All Purpose Building Permit Application

Location/Address of Construction: <u>29 MORNING ST, PORTLAND, ME</u>		
Total Square Footage of Proposed Structure <u>2362+-</u>	Square Footage of Lot <u>3334</u>	
Tax Assessor's Chart, Block & Lot Chart# <u>3</u> Block# <u>C</u> Lot# <u>15</u>	Owner: <u>JEFF DAVISON</u>	Telephone: <u>775-7137</u>
Lessee/Buyer's Name (If Applicable) <u>N/A</u>	Applicant name, address & telephone: <u>JEFF DAVISON</u> <u>29 MORNING ST.</u> <u>PORTLAND, ME 04101</u>	Cost Of Work: \$ <u>12,000</u> Fee: \$ <u>330.00</u>
Current use: <u>Single Family</u>		
If the location is currently vacant, what was prior use: <u>N/A</u>		
Approximately how long has it been vacant: <u>N/A</u>		
Proposed use: <u>SINGLE FAMILY RESIDENCE</u>		
Project description: <u>extending cable w/ dormer two decks</u>		
Contractor's name, address & telephone: <u>CURTIS HEWITT 625-8854</u> <u>CURTIS HEWITT 40 JEFF DAVISON 29 MORNING ST. PORTLAND, ME 04101</u>

Permit Number: 021079

has permission to Extending Gable with Dormer and (2) 5' Decks and (1) 12' x 3'4" Rooftop Deck

6 Proposed Deck Railings
SCALE: 1/2" = 1'-0"

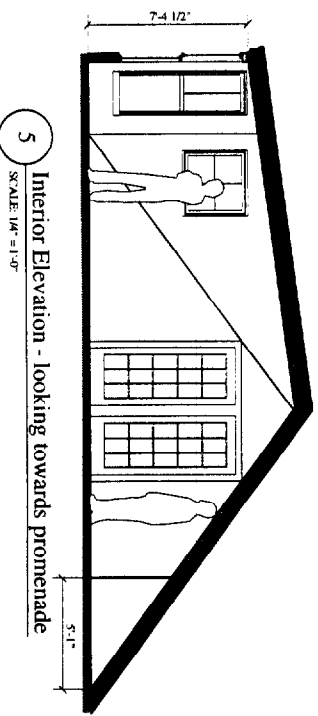
Code Compliant Guards (36 inches in height with openings less than 4 inches without a ladder design) are required on both sides of the stairs
